Norfolk Boreas Offshore Wind Farm Applicant's Comments on Deadline 5 Submissions

Applicant: Norfolk Boreas Limited
Document Reference: ExA.ASR.D6.V1
Deadline 6

Date: March 2020
Revision: Version 1
Author: Royal HaskoningDHV

Requirement 16 (5)
Buildings must not exceed 19m

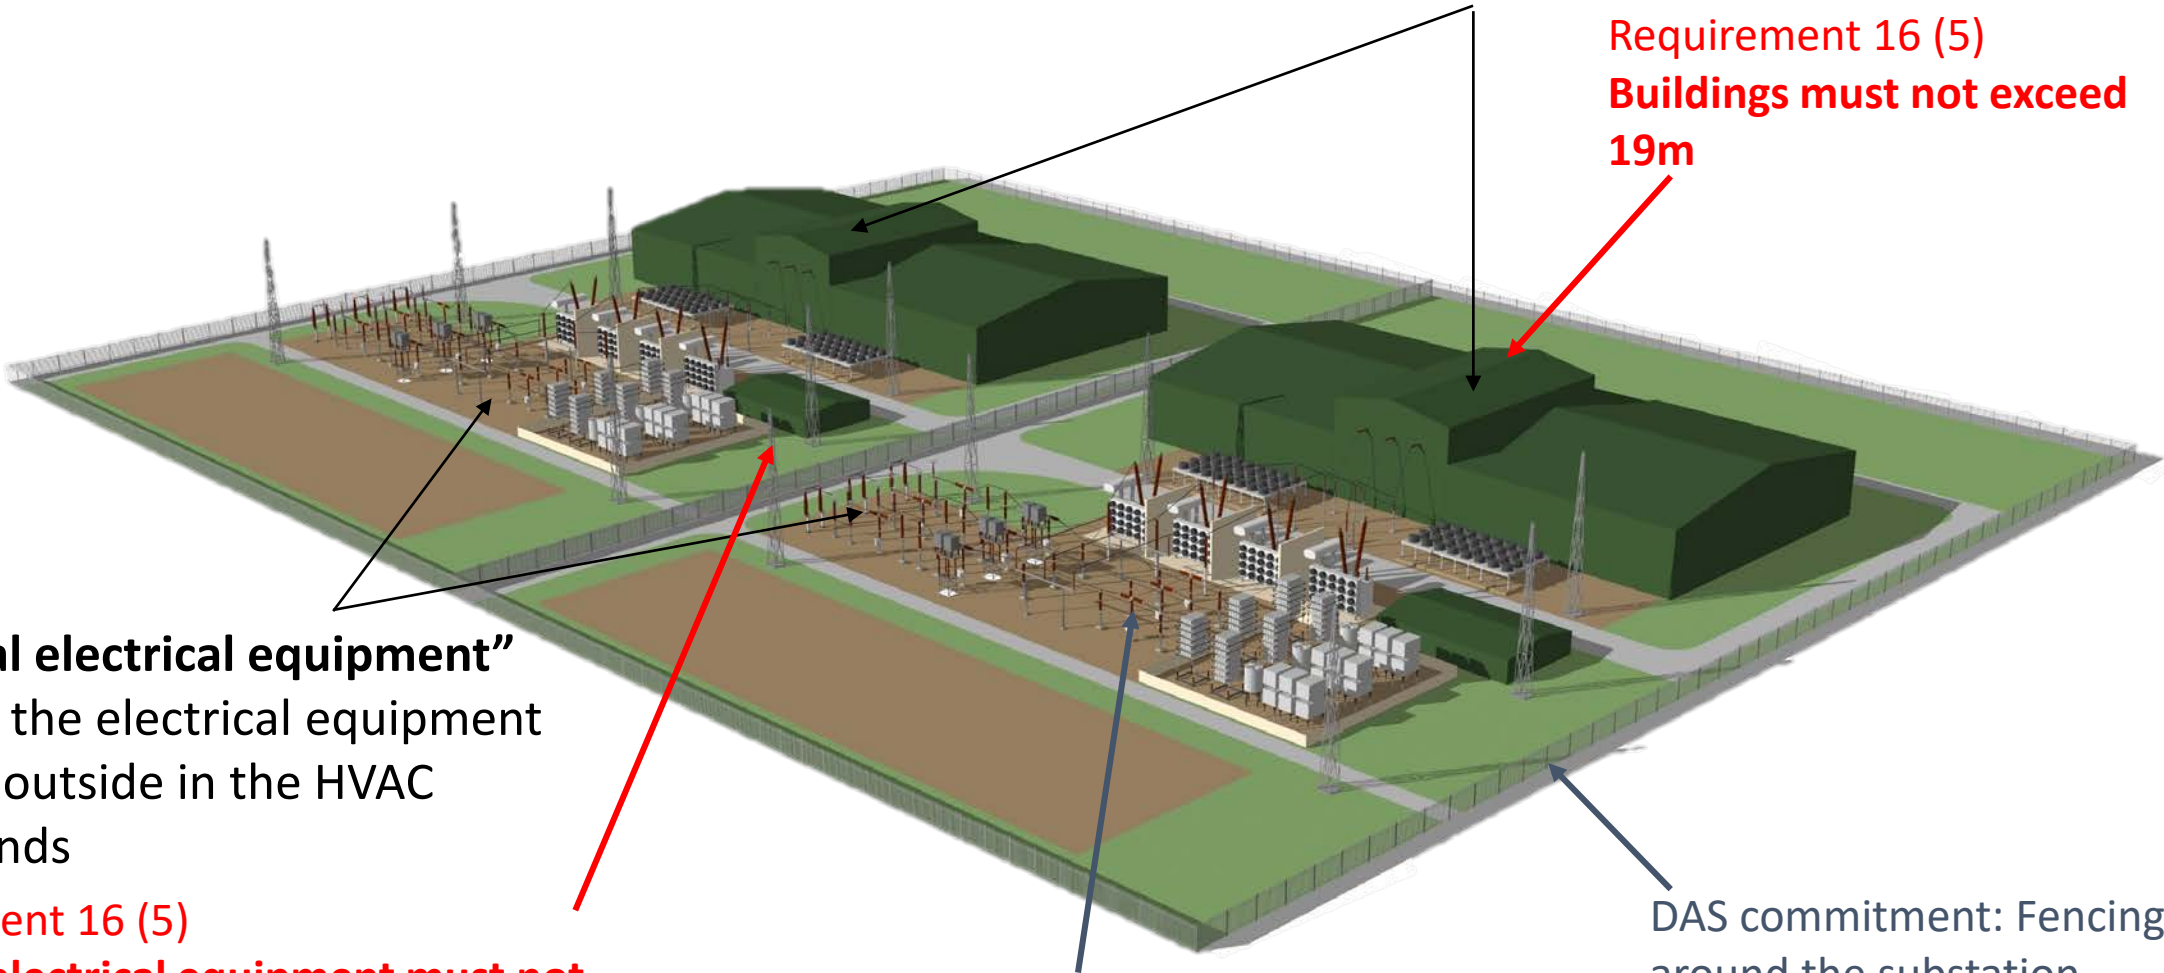
Summary of Submission	Applicant's Comments
Sub-station buildings	
<p>REP5-093 raises concerns around the height of the buildings which are presented in Works No. 8A. It is of concern that that base levels for footings, foundations and floor levels at the onshore project substation may be higher than existing ground level. <i>‘If such base levels are higher than the existing ground levels it follows that their equipment will be higher than that stated from the existing ground level and of course more visible than predicted on photomontages, etc’</i></p>	<p>The dDCO secures the maximum height of buildings and external electrical equipment above existing ground level associated with the onshore project substation through dDCO Requirement 16(5): <i>‘Buildings comprised in Work No. 8A must not exceed a height of 19 metres above existing ground level and external electrical equipment comprised in Work No. 8A must not exceed a height of 25 metres above existing ground level’</i></p> <p>The existing ground level is also defined and secured within the dDCO through dDCO Requirement 16(8): <i>(8) For the purposes of paragraph (5) of this requirement, (a) In the event of scenario 1, ‘existing ground level’ means 73 metres above ordnance datum; and</i></p>

Summary of Submission	Applicant's Comments
	<p><i>(b) In the event of scenario 2, 'existing ground level' means 72 metres above ordnance datum.</i></p> <p>These requirements work together to limit the height of the buildings and external electrical equipment with reference to existing ground level which are defined heights above ordnance datum. These existing ground levels (defined ordnance datum heights) and maximum building and outside electrical equipment heights are the basis on which photomontages and other landscape and visual assessments have been conducted.</p> <p>For clarity, as an example on how these requirements work together to limit the maximum heights, the maximum height of the onshore project substation buildings in the event of scenario 1 is 92m above ordnance datum as derived by a secured 73m existing ground level plus a secured 19m maximum building height.</p> <p>Continuing this example with reference to a raised base level, if the base level was 1m above the secured 73m existing ground level (to 74m above ordnance datum), this would result in the buildings being required to be limited to 18m in height to comply with the maximum building height of 19m from the secured 73m existing ground level.</p> <p>Therefore, the onshore project substation buildings and outside electrical equipment maximum heights as secured in Requirement 16(5) cannot be higher than stated from the existing ground levels as secured in dDCO Requirement 16(8).</p>
